74 Hall Ing Lane  
Honley  
Holmfirth  
HD9 6QR

We would like to express our concerns over the proposed development at Hollinhurst Farm, Hall Ing Lane, Honley (Ref 2024/93594). The development is situated immediately adjacent to the northern boundary of our property, 74 Hall Ing Lane (note shown incorrectly as No. 76 on ordnance survey maps). The application is a variation of previous planning submission Ref 2018/62/92754/W and does not appear to address previous concerns or that of neighbouring properties.

DRAWING DESCRIPTION	
PROPOSED SITE SECTIONS PLOTS 1-3	
JOB TITLE	
HOLLINHURST FARM	
CLIENT	
KINGSMAN HOMES	
DRAWN BY	SCALE: 1:100 @ A1
DATE: DEC 2024	DRAWING NO: 1/220-90-08
CHECKED	REVISION

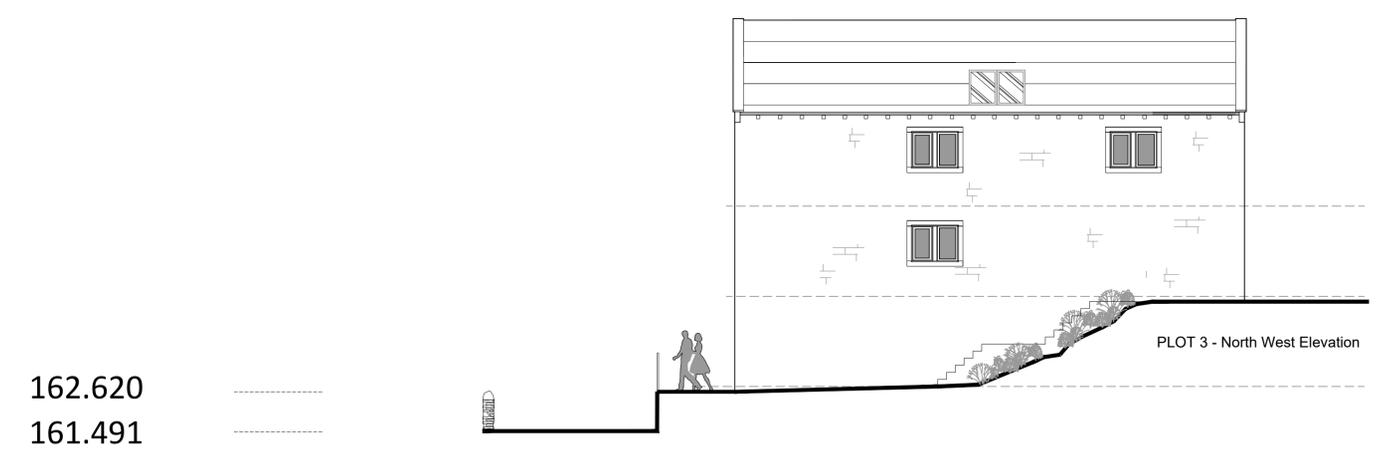
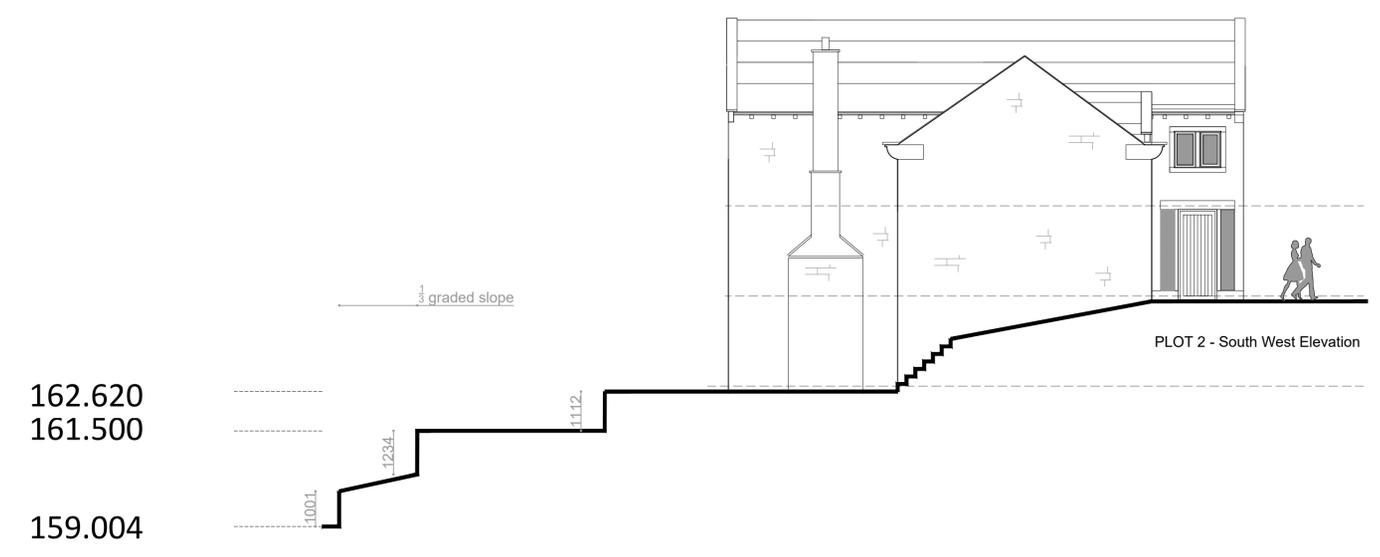
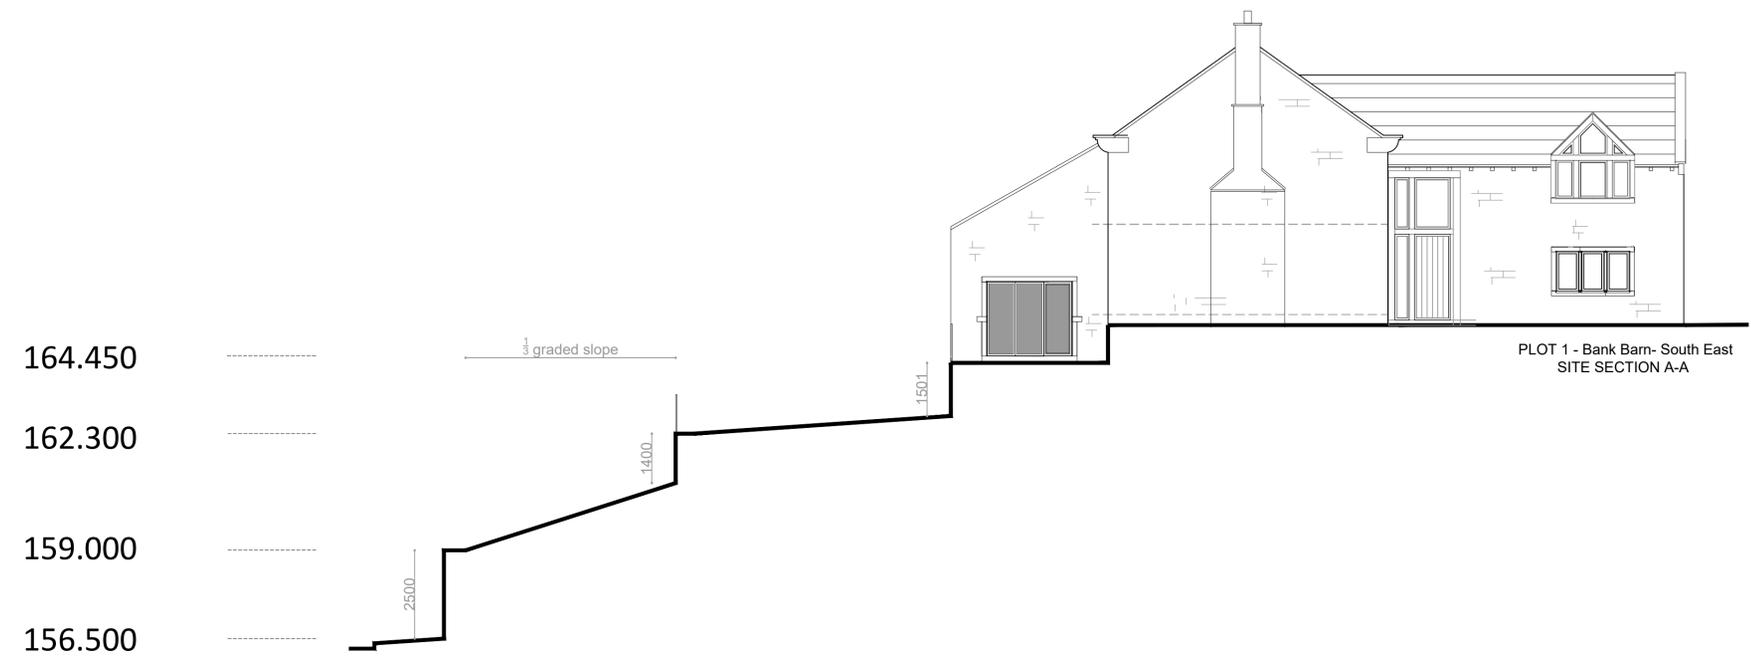
The elevations for plots 1-3 indicate significant retainment split between a number of walls to retain a total height of 5.4m. The overall impression however would be of a single wall. This will have a significant visual impact on the landscape which occupies a prominent position in the valley.

DRAWING DESCRIPTION
PROPOSED SITE PLAN
LONG SECTION

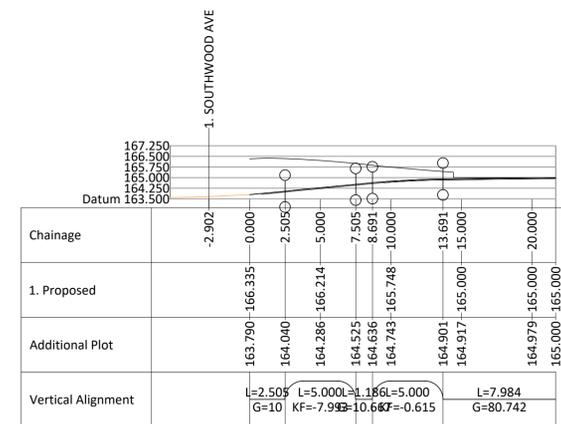
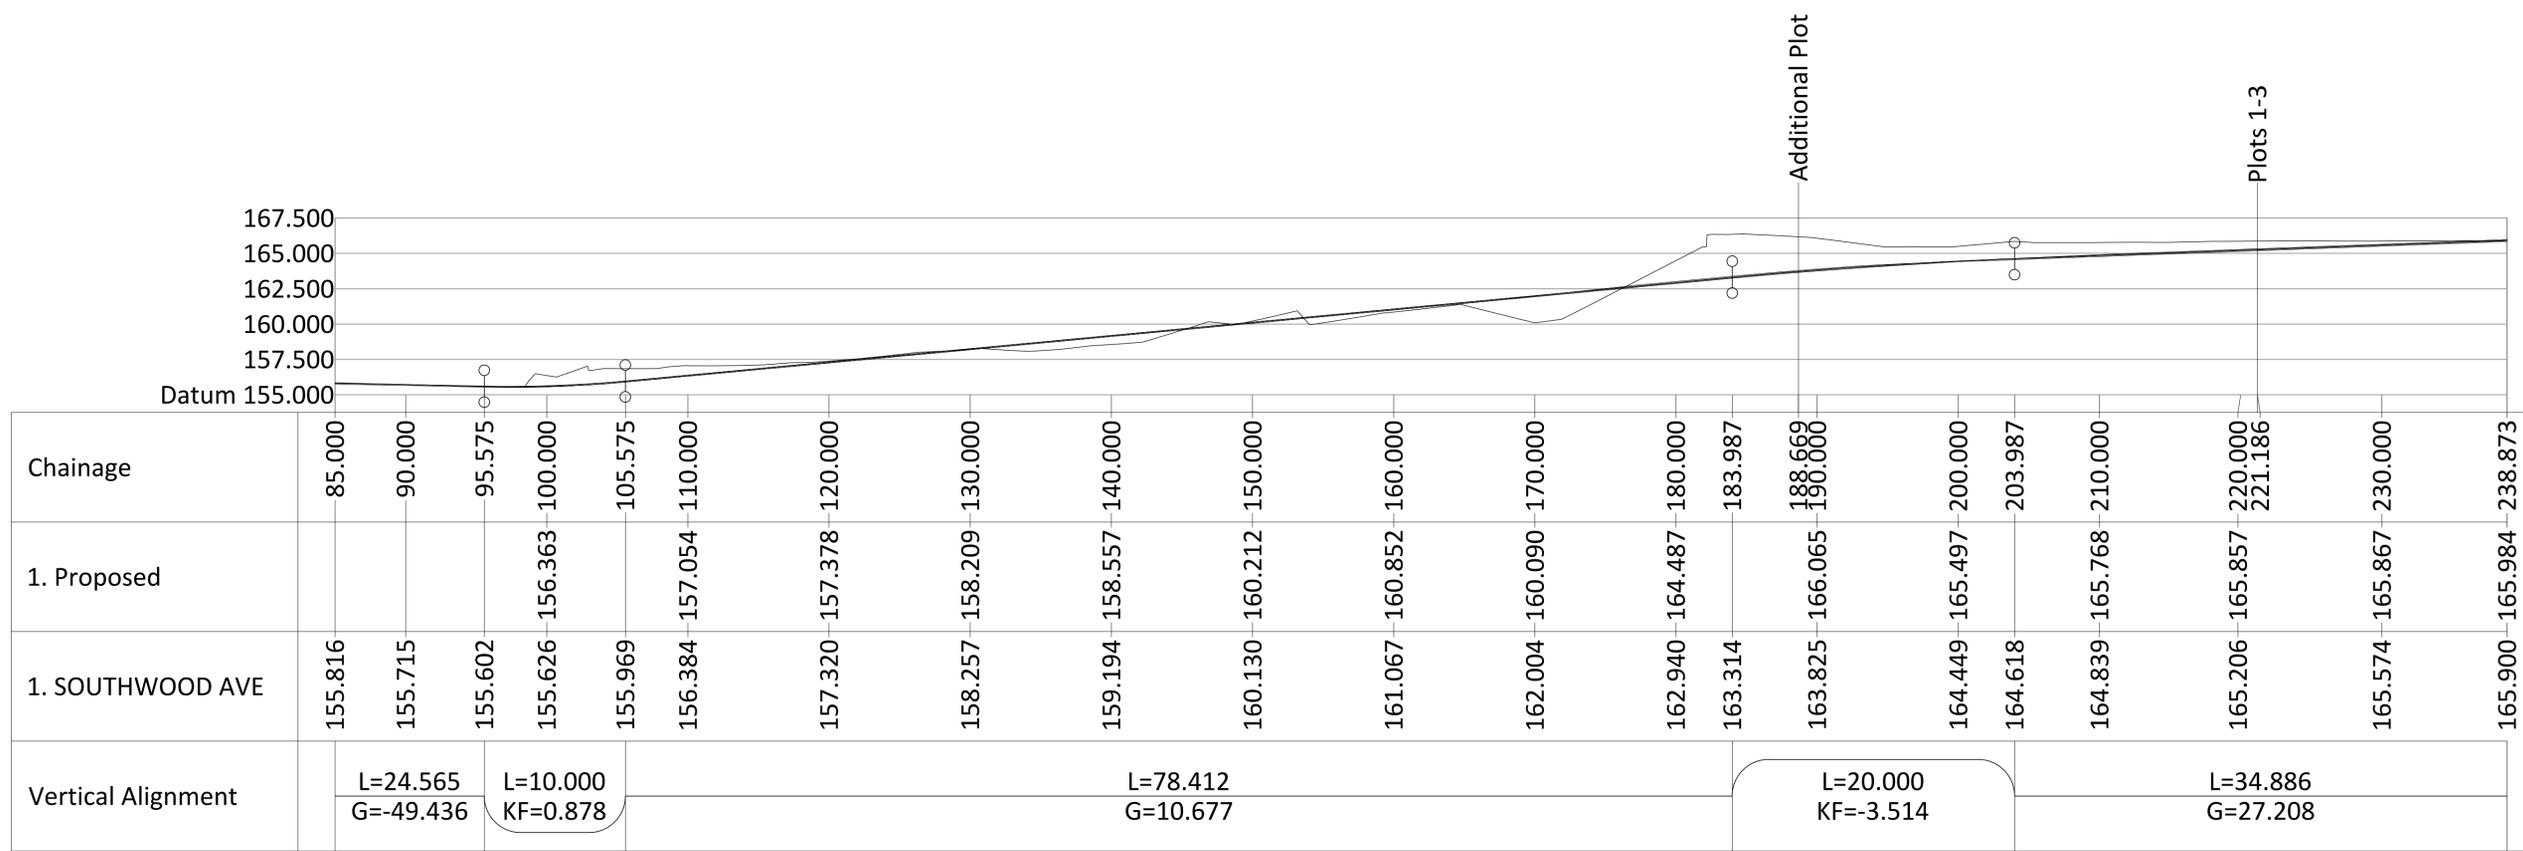
The issues of access to the site were raised as part of the local plan submission. The steep access to the site seems to have been ignored by the developer's proposals. The plan within the revised Transport Assessment and Road Longitudinal Section revised indicates an access road

gradient of **1:10.5**. A gradient of this magnitude would not normally be accepted for adopted highways or under Building Regulations Part M for main site pedestrian access. A gradient of 1:20 being the typical maximum. The gradient would not normally be acceptable for refuse vehicle access or pedestrians based on Kirklees Councils Highway Design Standards.

DRAWING DESCRIPTION			
PLOT 8			
JOB TITLE			
HOLLINHURST FARM			
HONLEY			
CLIENT			
Kingsman Homes			
DRAWN BY		SCALE	1:100 @ A1
DATE		DRAWING NO.	REVISION
December 2024		1020/00-07	.
CHECKED

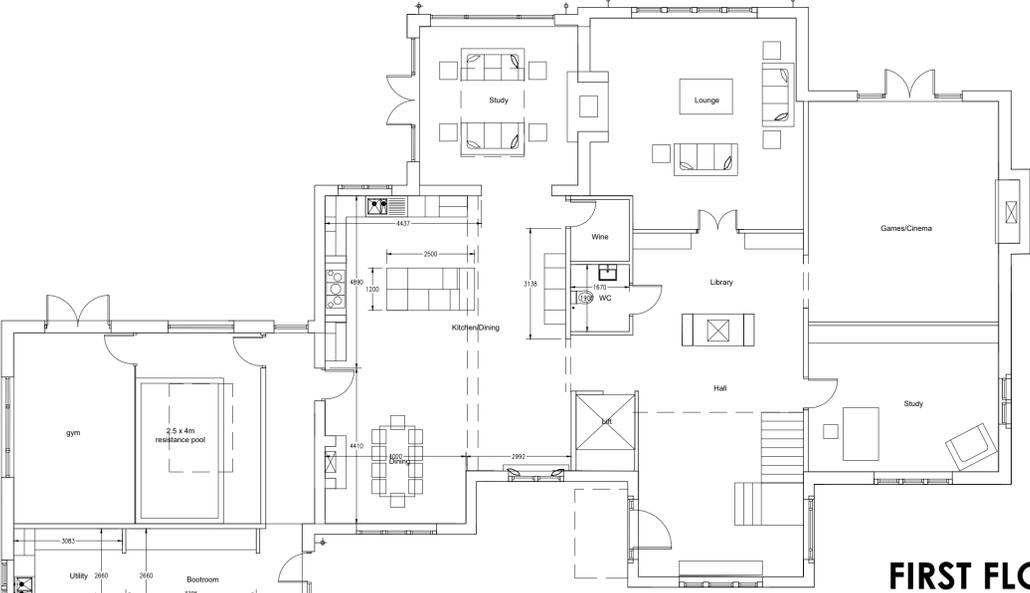
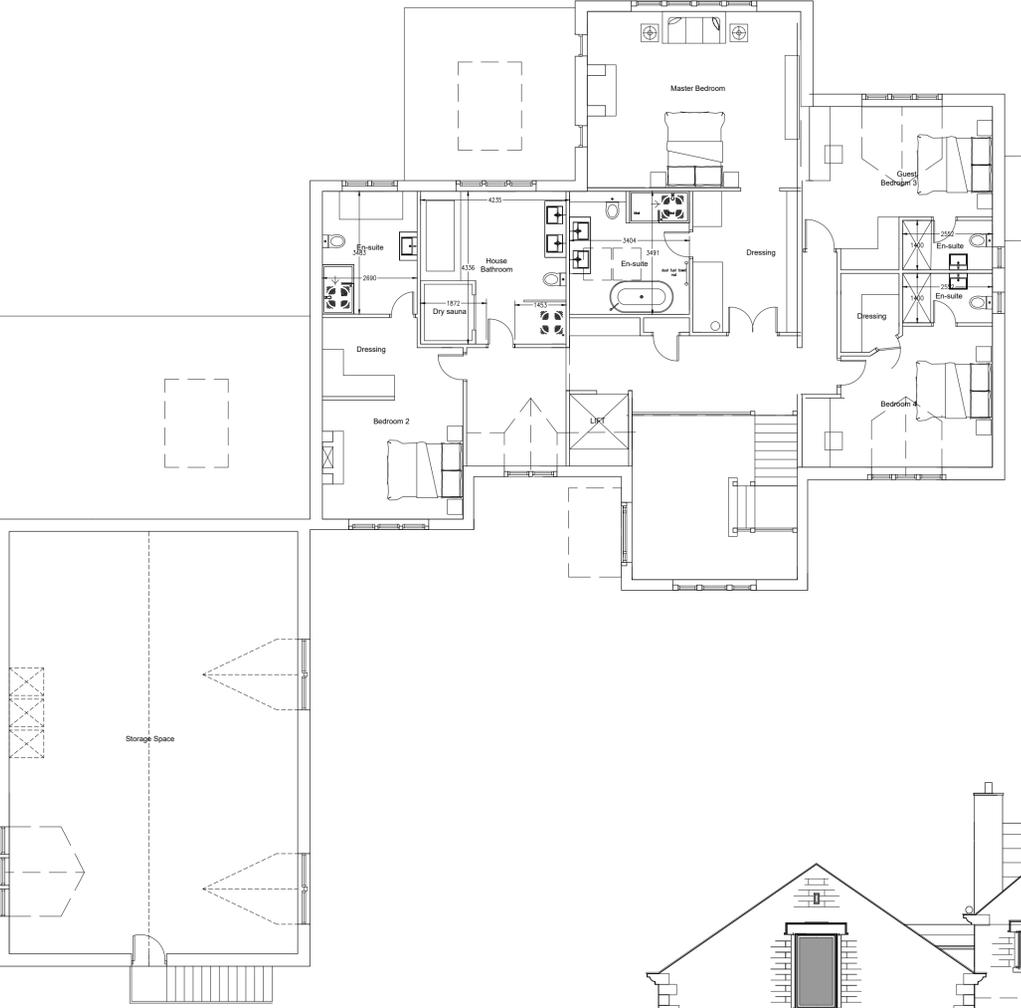
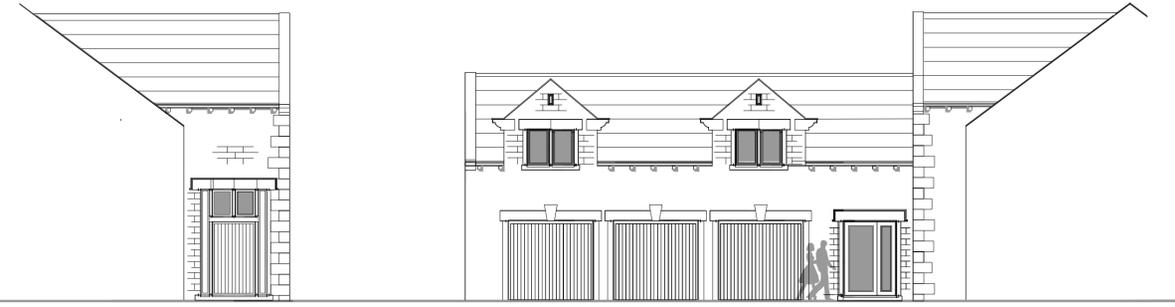
**Proximity** - Plot 8 is situated directly opposite our boundary and facing our property. We understand that the UDP BE12 guidance is that a minimum offset of 10.5m should apply between a building (with windows on elevation ) and boundary to undeveloped land. Whilst there is an improvement since previous application the property is only situated 8m from our boundary. We also note that the redline boundary is shown incorrectly on the site plan and the 'hedge' indicated is within our ownership and confirmed by our deeds.

The plan layout for Plot 8 indicates that the primary inhabited rooms (kitchen, lounge, study and master bedroom) are situated on the elevation facing our property.

**Glazing** - The rear elevation facing our property is extensively glazed with 31 windows. These include 4 no. full height patio doors / windows to the Gym, Study, Lounge and Games Room and full height glazing to the master bedroom. The latter is of particular concern as anyone entering the bedroom will unavoidably look down into our garden below. Considering the proximity of the property to the boundary this will be intrusive.

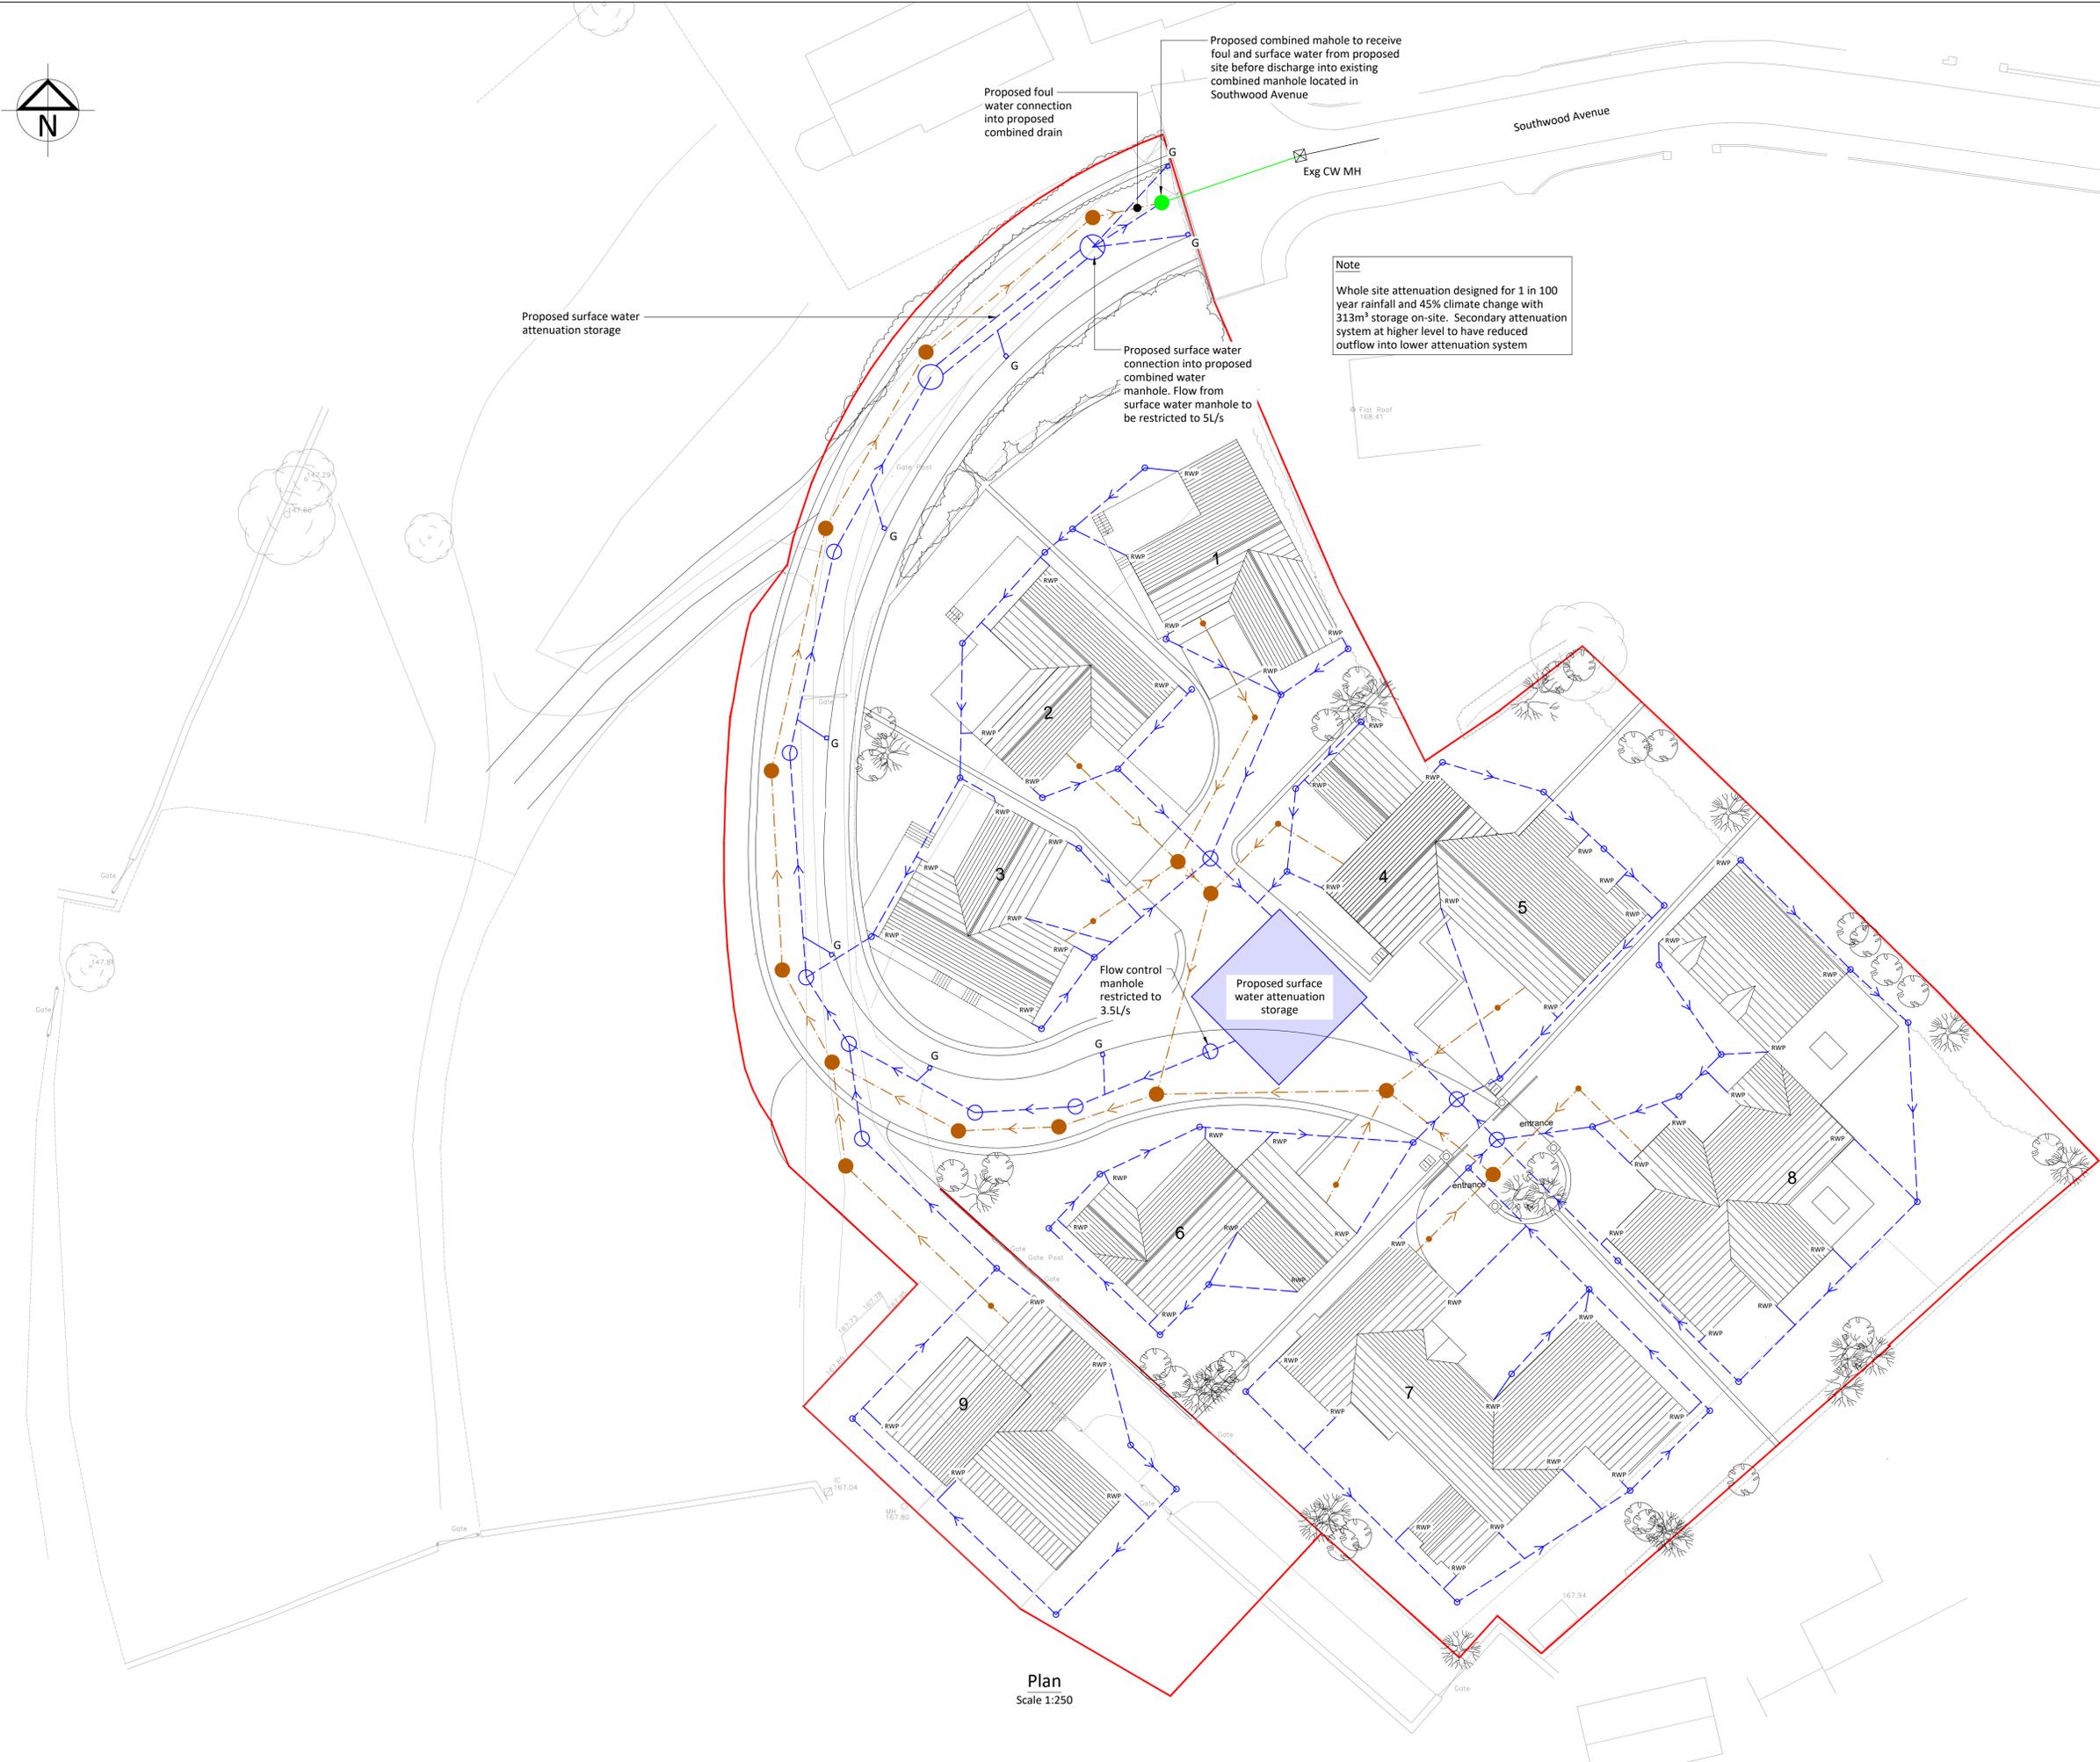
The drainage strategy is contradictory with the summary stating that the drainage for the site will discharge surface water to 'surface water sewers' on Southwood Avenue which are not known to exist. Latter in the same report connection is proposed to the Yorkshire Water Combined Sewer on Southwood Avenue. This does not represent a sustainable drainage approach.

Due to the gradient of the access road there would be a risk that gullies would be bypassed by flows potentially leading to flooding on Southwood Avenue which is relatively flat.
